To Kathryn Hughes
From Joanne McKay – Growth Lancashire
Subject Conservation Comments
Date 03/03/2023

Ref: 3/2022/0978

Proposal: Listed Building Consent for the internal re-ordering of listed building and later extensions to create a better 'flow' around the property. Alterations include: re-siting the kitchen, re-instating the former entrance doorway, changing the existing kitchen to a distinct entrance, boot room/utility, create third bedroom from large bathroom and circulation space, retain 'secret' doorway through original external gable, partial removal/demolition of internal wall to 18th century extension to allow a new small timber staircase. No alterations are proposed to the external appearance of the building.

Site Address: Little Blacksticks, Blacksticks Lane, Chipping Lancashire PR3 2WL

GROUND FLOOR PLAN

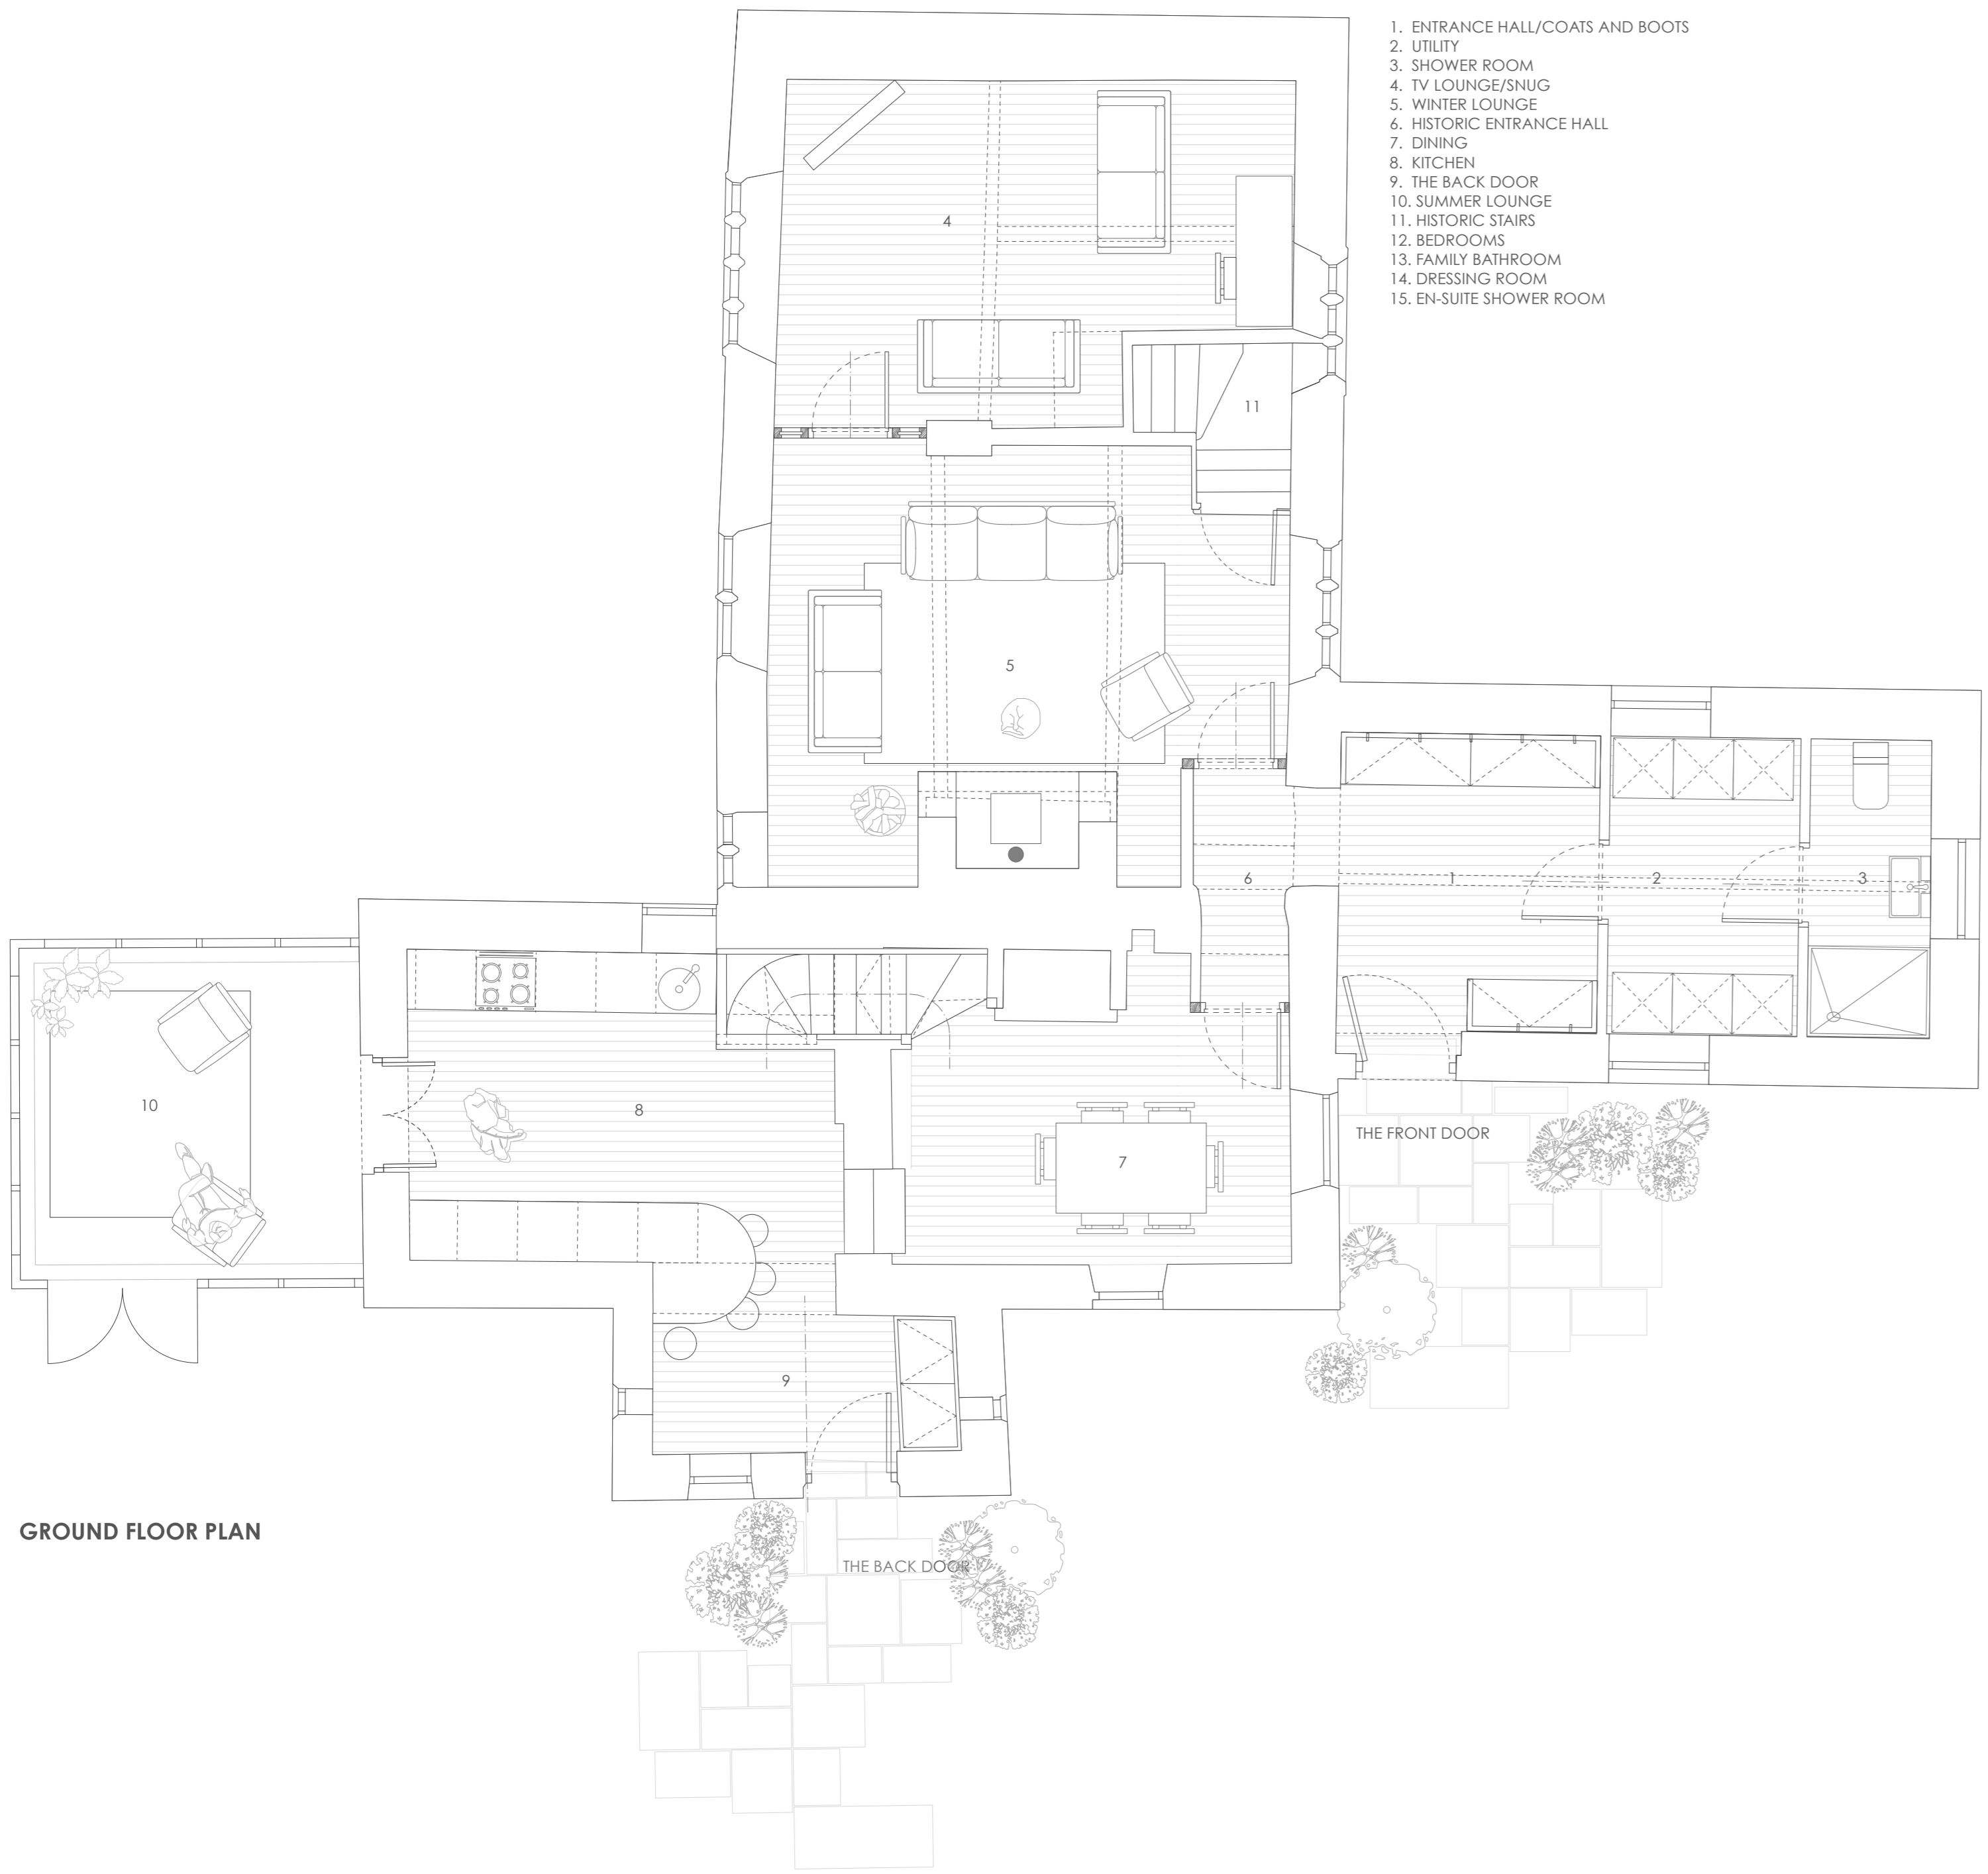
I raise no concerns in respect of the subdivision of the existing kitchen to create the boot room, shower and W.C. However whilst this part of the house is a later C19 extension it remains of some interest and as such, further details should be sought in relation to the beams and how they will be dealt with when subdividing the former kitchen. This probably can be dealt with via a suitable worded Condition.

The main and most significant intervention is that of the installation of the new timber staircase, located in the C18 part of the building, which will result in some loss of the historic wall and ceiling. Nevertheless, I acknowledge and accept the need for a cohesive flow within a family home and the proposed work and loss of historic fabric may not necessarily translate into a level of substantive harm but rather an adaption and better use of the historic building. In addition, although an earlier part of the building, there are exposed timber floor joists, which are noted in the Design and Access Heritage Statement as being modern. I agree with this suggestion.

FIRST FLOOR PLAN

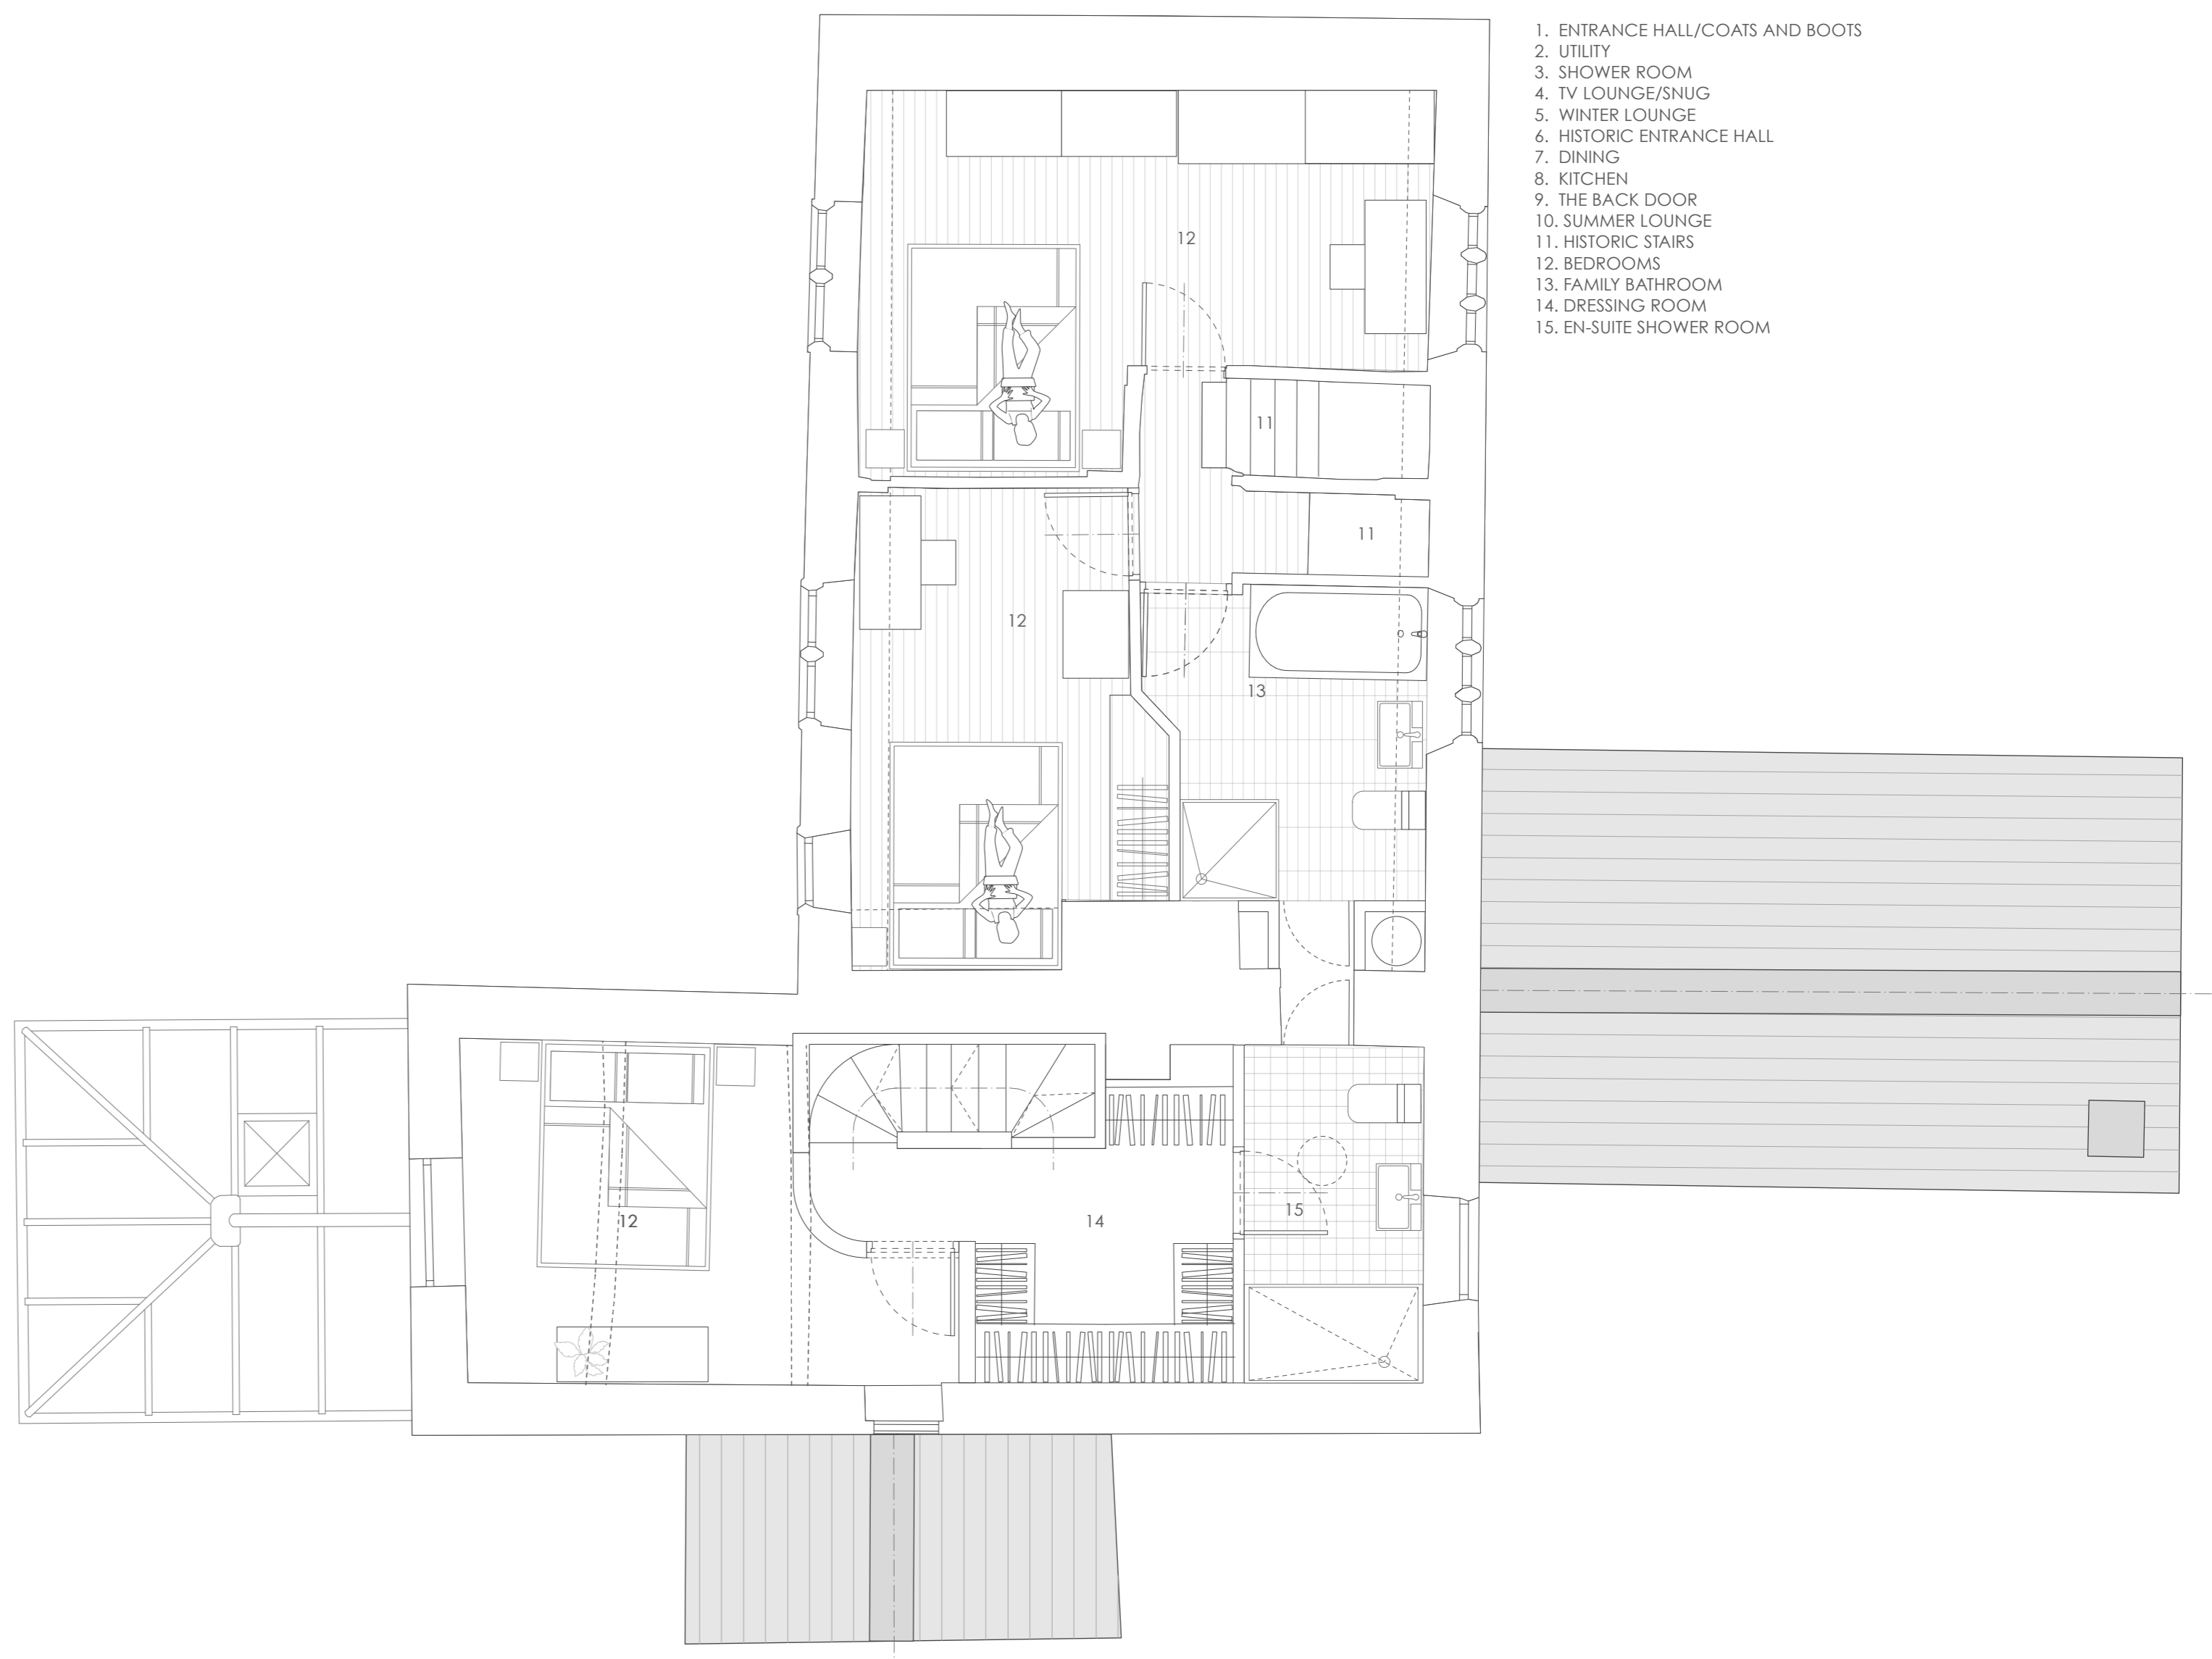
On the upper floor, where the new stairs are to be located, the plans include what appears to be a newly proposed curved wall that will separate the master bedroom from the dressing room and en-suite and will house a new door. Located on the ceiling of the bedroom are two exposed timber beams and it is unclear from the plans how the proposed new curved wall will relate to the existing beams. Additionally, there is a change in floor level and it is unclear how this will be managed within the new scheme, particularly with the proposed new staircase and curved wall. As such, I suggest that further details, including suitable cross-section(s), should be provided in relation to this aspect of the work to ensure any harm is mitigated through the design/construction.

Therefore, subject to further clarification of the works relating to the timber beams in the C18 & C19 element, the construction of the new curved wall and the changes in floor levels, it is likely that any harm caused as a result of the proposed works will be of a negligible scale, which could be adequately managed via the submission of a work methodology to confirm the detailed finishes and work procedures.
